Our ref: DOC21/238759
Senders ref: SSD 10479

Subject: amended plans and documentation for the proposed 200 Aldington Road Industrial Estate (SSD-10479) in response to issues raised with the Applicant's Response to Submissions

Attachment A – EES comments on Response to Submissions for 200 Aldington Road Industrial Estate (SSD-10479)

BIO-RETENTION BASIN B
SECTIONS

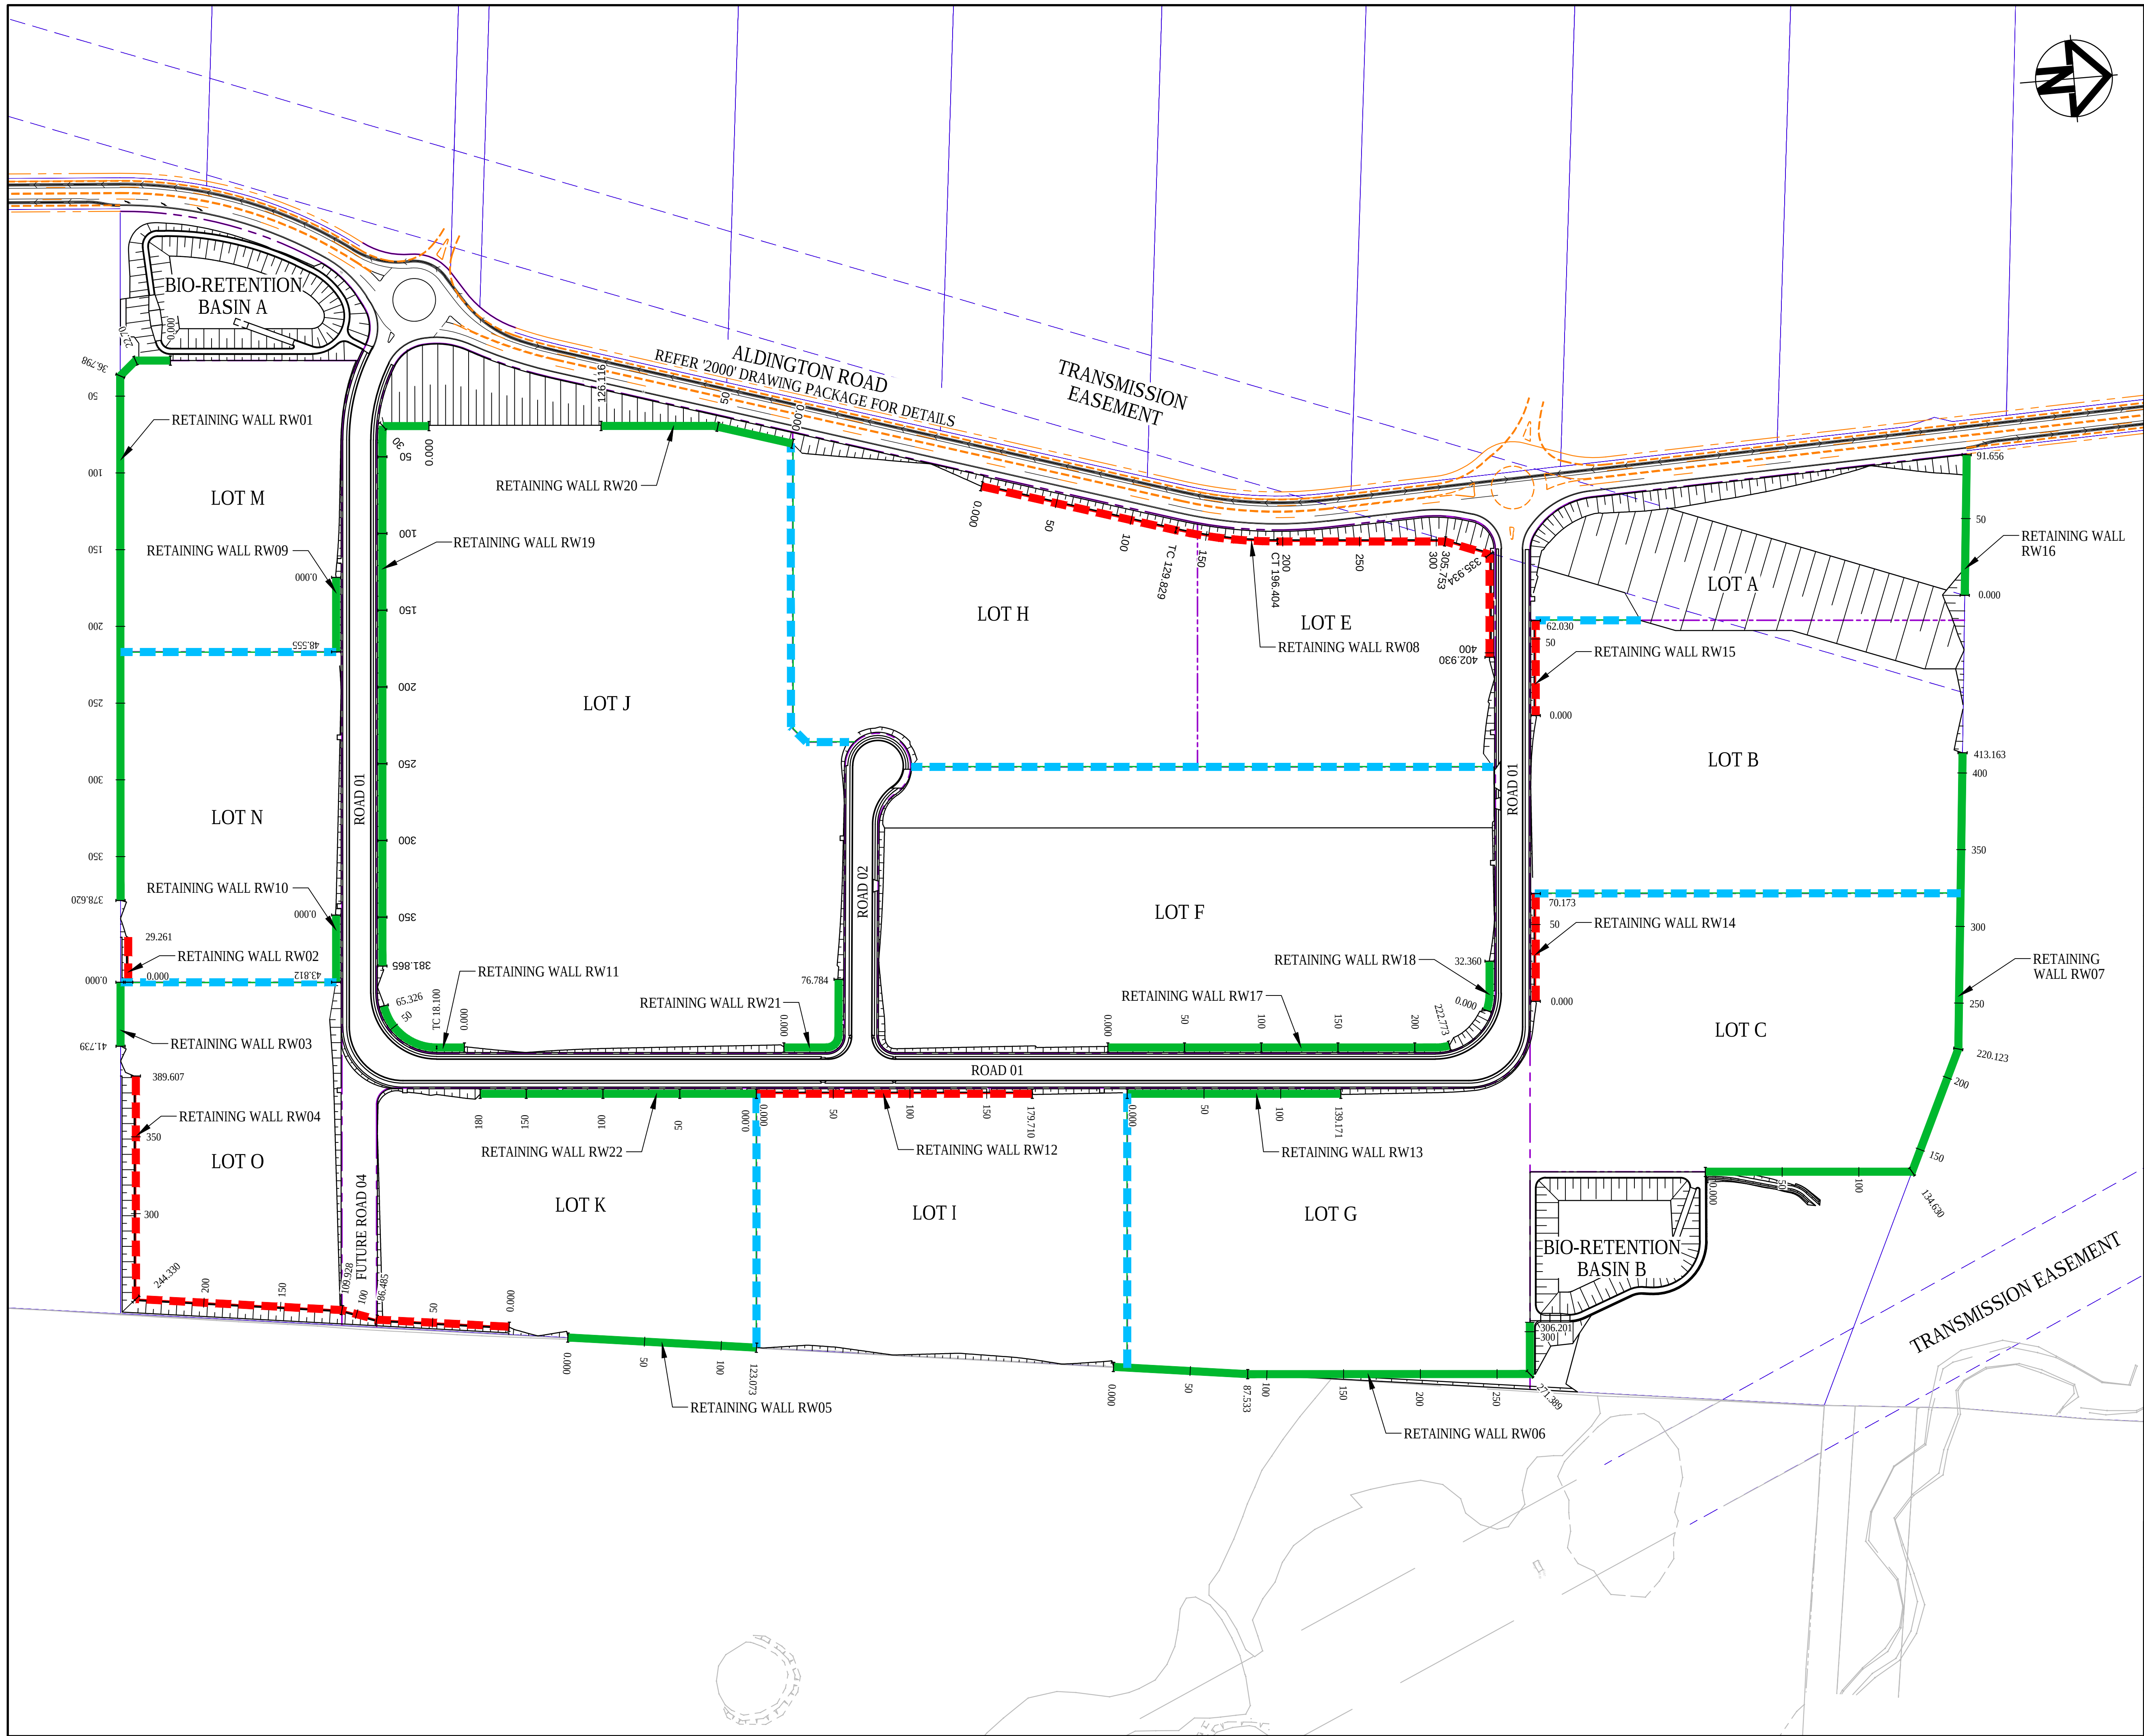
The revised concept plan is similar to the previous concept plan, reviewed by EES as part of the applicant's previous RtS, although EES notes that the size of Basin B at Lot D has increased.

- No information is provided on the rainfall period and potential evapotranspiration parameters that were used for the development of MUSIC X. EES therefore requests that the applicant supply the MUSIC X model as part of the submission to review.
- Scenario 1 cannot be considered by EES, as we have not had confirmation that a regional approach is a viable strategy for the Mamre Road Precinct.
- Scenario 2 meets the Operation Phase Targets Stormwater Quality and Quantity Targets, on the basis that much of the site is undeveloped. To demonstrate that the larger Basin (B) at lot

D in the concept plan achieves the targets, EES requests that the applicant provide their MUSIC X model and supporting excel spreadsheet titled 'Flow Duration Curve Development Scales – South Creek – Locked.xlsx' for review. On this basis, EES cannot make a comment on the feasibility of Scenario 2, at this stage.
